App No: F/16/18/DOC

Address: Land South Of Burndell Road Yapton BN18 0HR

Proposal: Application for approval of details reserved by conditions imposed
on planning reference F/7/15/OUT relating to Condition 16 –
Ecology & Condition 17 - External Lighting

HALF LANTERN BLACK LED 600 HILO

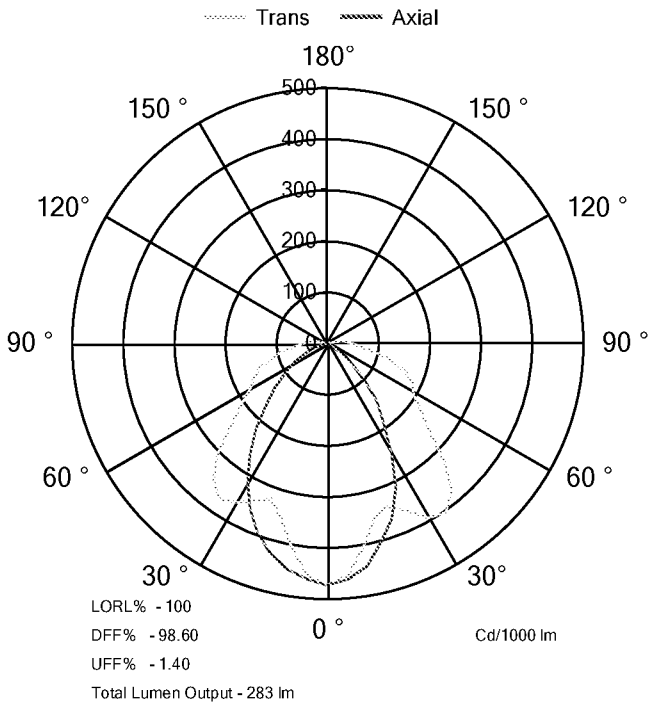
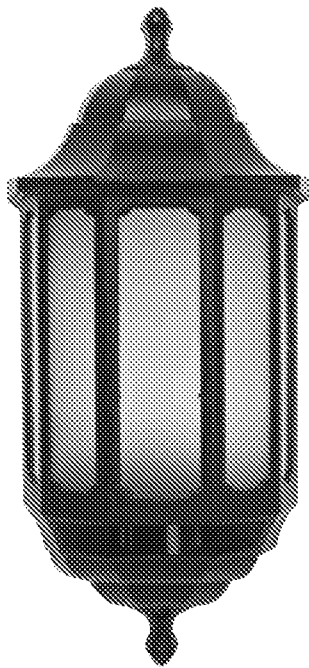
We would like to see that the half lanterns are changed for directional lighting to avoid light spill beyond the boundary of the area being lit and also to avoid the upward spread of light (above 90°).
